Department of Transportation

May 14, 2019

SH 85
El Paso County

RE: South Academy Business Center - Barry Helton
Board of Adjustment- Setback Variance

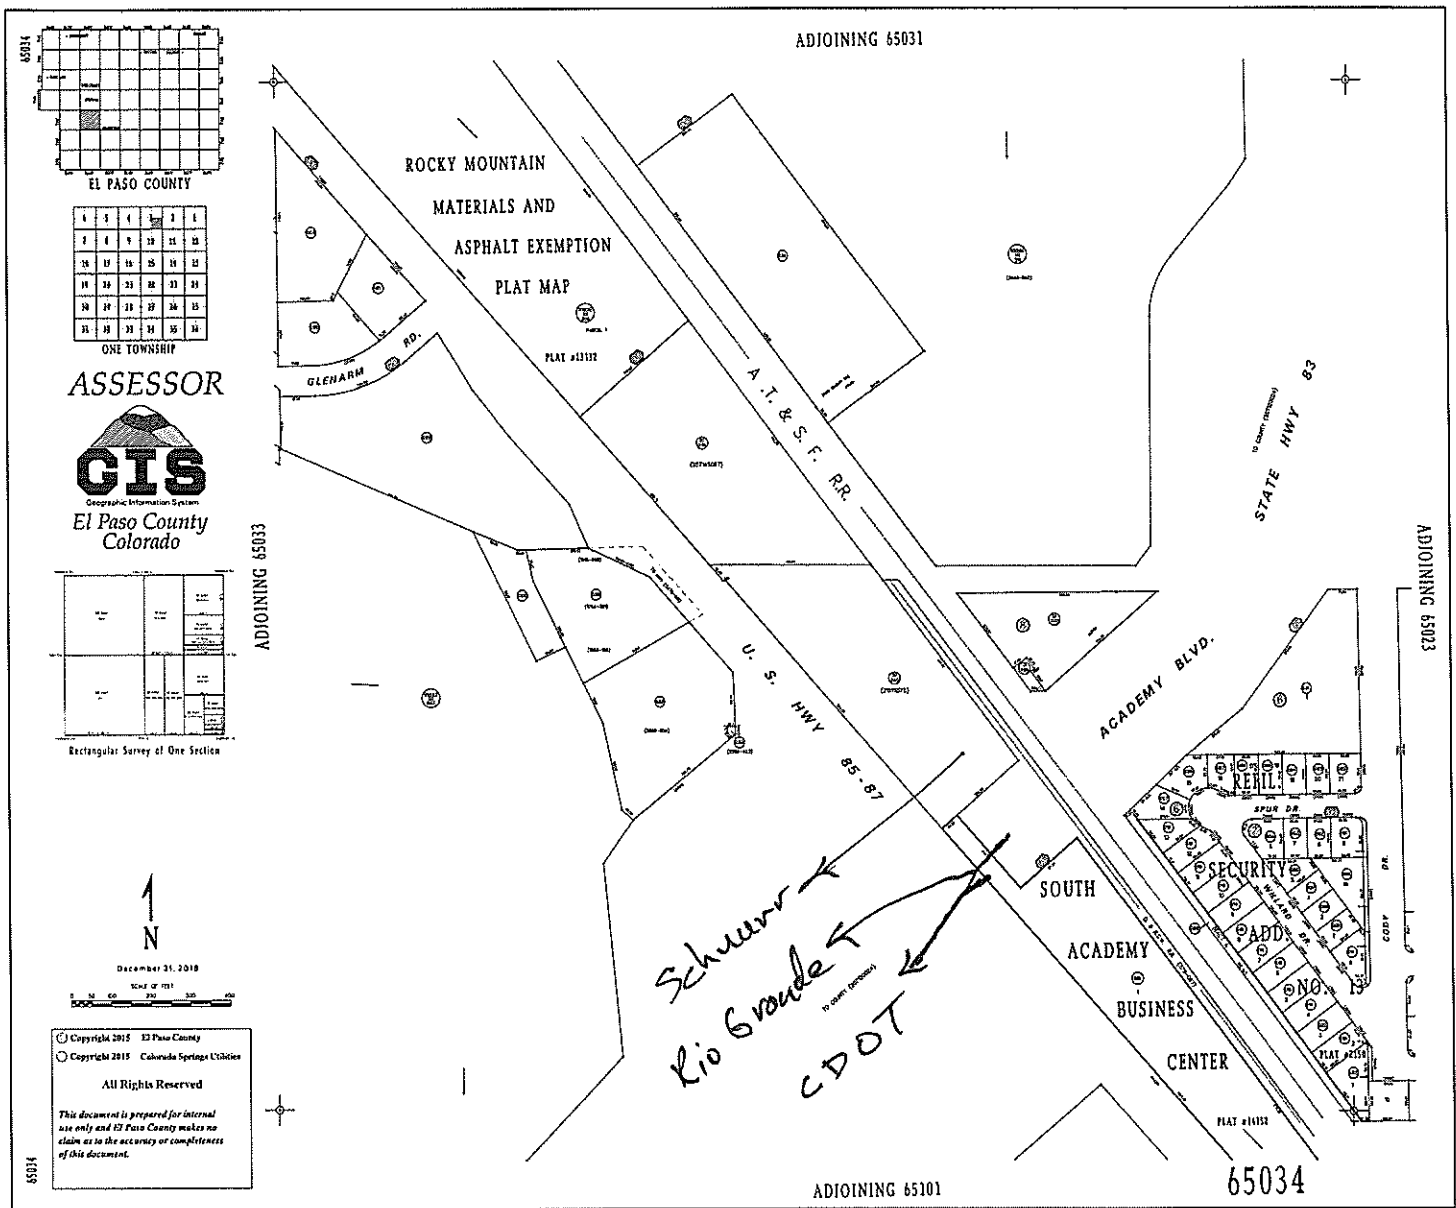
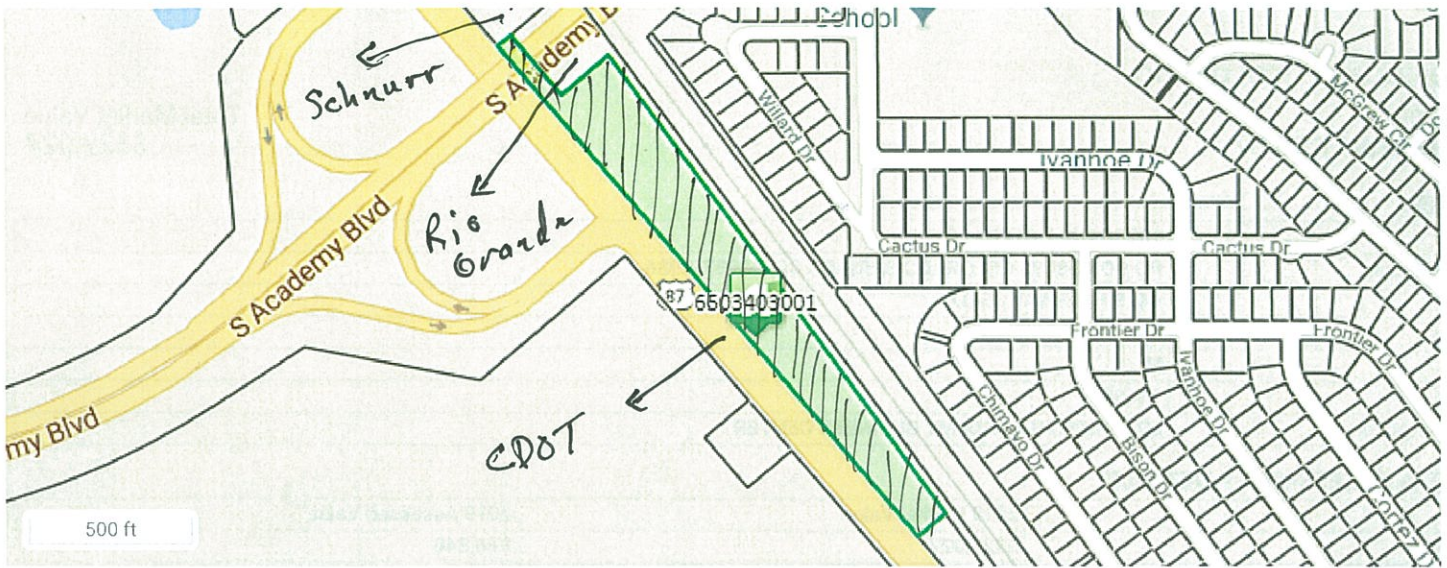
- CDOT does not have setbacks. However, the exhibit provided is too convoluted to determine the precise right-of-way alignment which is crucial for public safety. Please resubmit with unnecessary layers removed and at a larger scale.
- Any regrading of property adjacent to or within CDOT ROW will require an engineered grading plan that will be reviewed by a CDOT Hydraulics Engineer. If acceptable, the grading work will require a Special Use Permit obtained through the CDOT Utilities Unit.
- We also inquire as to how the ROW lines were established for the exhibit. Were property pins or ROW markers located? If so, they need to be documented on the exhibit.
- Additional phases of the Load and Lock storage facility will require additional access permit(s), as highway improvements will be required.
